# CITY OF ALBUQUERQUE

Re: **505 Organix**  
**2121 Menaul Blvd NE**  
**Traffic Circulation Layout**  
Architect's Stamp 11-12-2021 (H16-052)

Based upon the information provided in your submittal received 01-03-2022, the above referenced plan cannot be approved for Building Permit until the following comments are addressed:

A4 TRAFFIC CIRCULATION PLAN

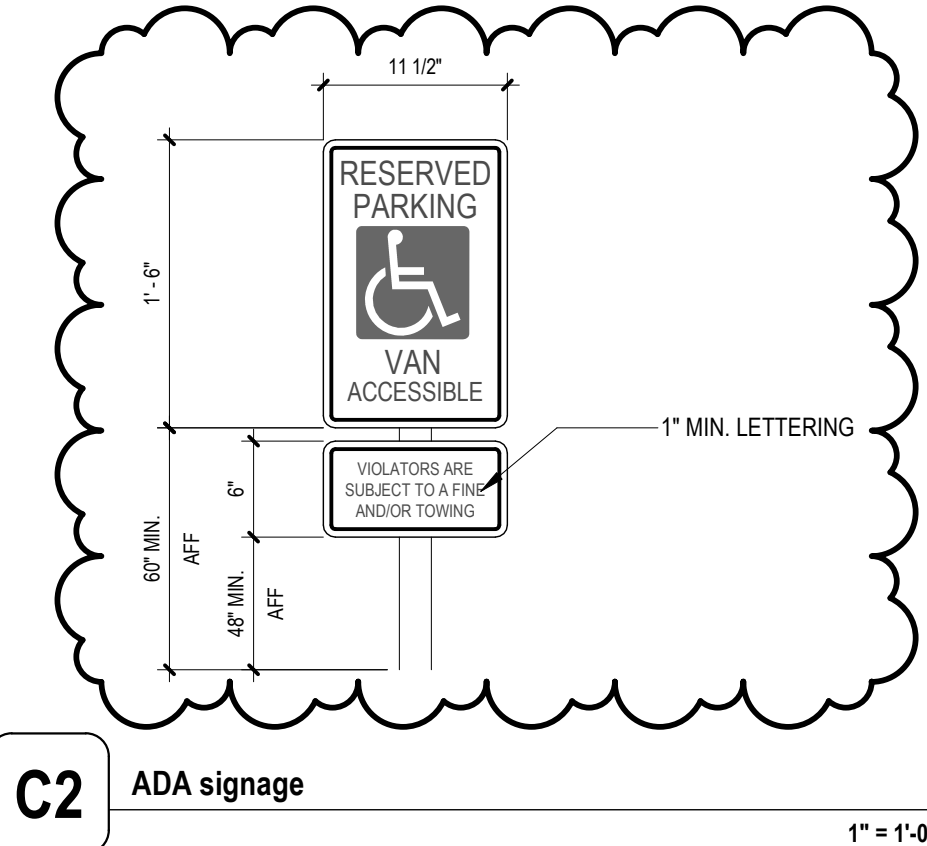
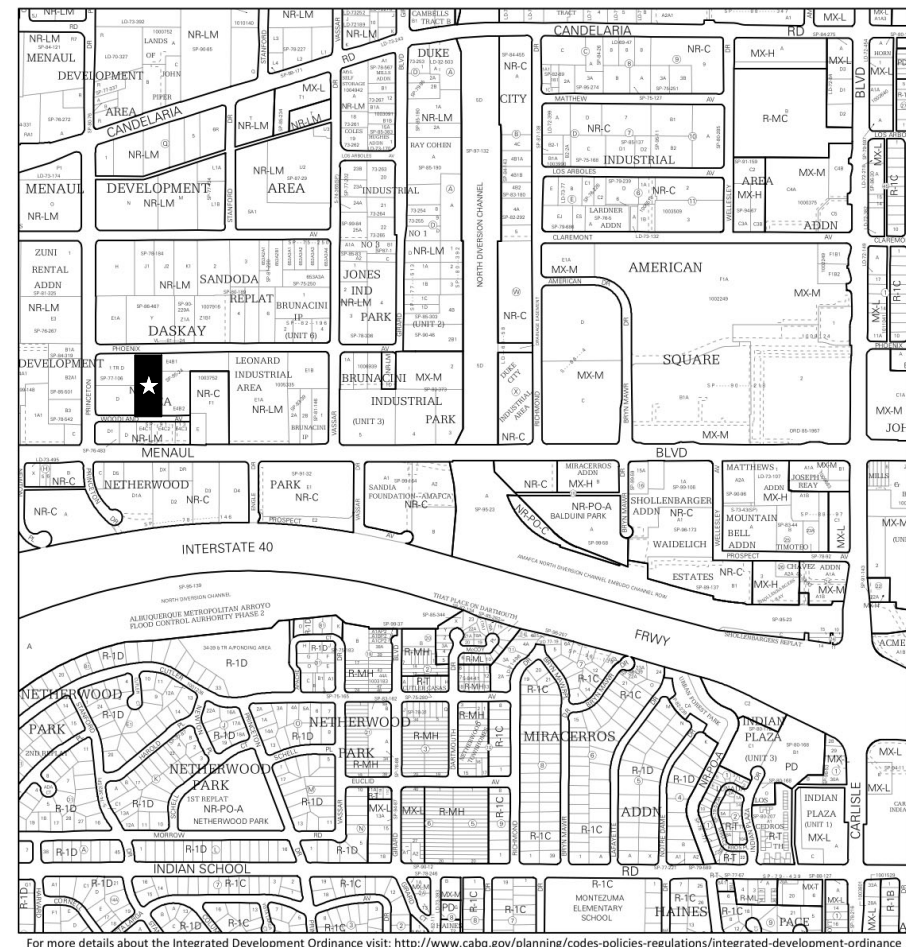
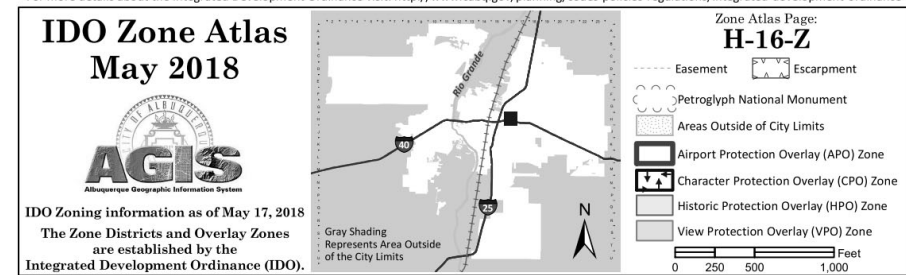
1. List the number of parking spaces required by the IDO as well as the proposed number of parking spaces including bicycle and motorcycle parking. **Coordinate/discuss with Zoning.**

3. All proposed on site infrastructure shall require details (including signage, pavement markings, striping) per Keynotes.
4. Proposed gate off Phoenix will need to be 20 ft from face of curb. Please adjust if this requirement has not been met.

5. Woodland frontage:
  - Building A (Existing parking stalls): It appears that parking stalls are designated to backout onto public street. This is not acceptable at present moment. Please explain strategy. **Discussion required.**

7. Identify the right of way width, medians, curb cuts, and street widths on Phoenix and Woodland.
8. Please list the width and length for **all existing** and proposed parking spaces. Some dimensions are not shown. If diagonal, show angle.

10. The ADA accessible spaces must include an access aisle. Van accessible aisles should be **8ft wide**; all others should be 5ft wide.
11. The ADA accessible parking sign must have the required language per 66-7-352.4C NMSA 1978 **"Violators Are Subject to a Fine and/or Towing."** Please call out detail and location of signs.

13. Phoenix existing driveway must be updated to current ADA standards. Please verify.
14. Motorcycle parking spaces shall be designated by its own conspicuously posted upright sign, either free-standing or wall mounted per the zoning code. Label pavement MC.

19. Per DPM, a 6 ft. wide ADA accessible pedestrian pathway is required from the ADA parking stall access aisles to the building entrances. Please clearly show this pathway and provide details.
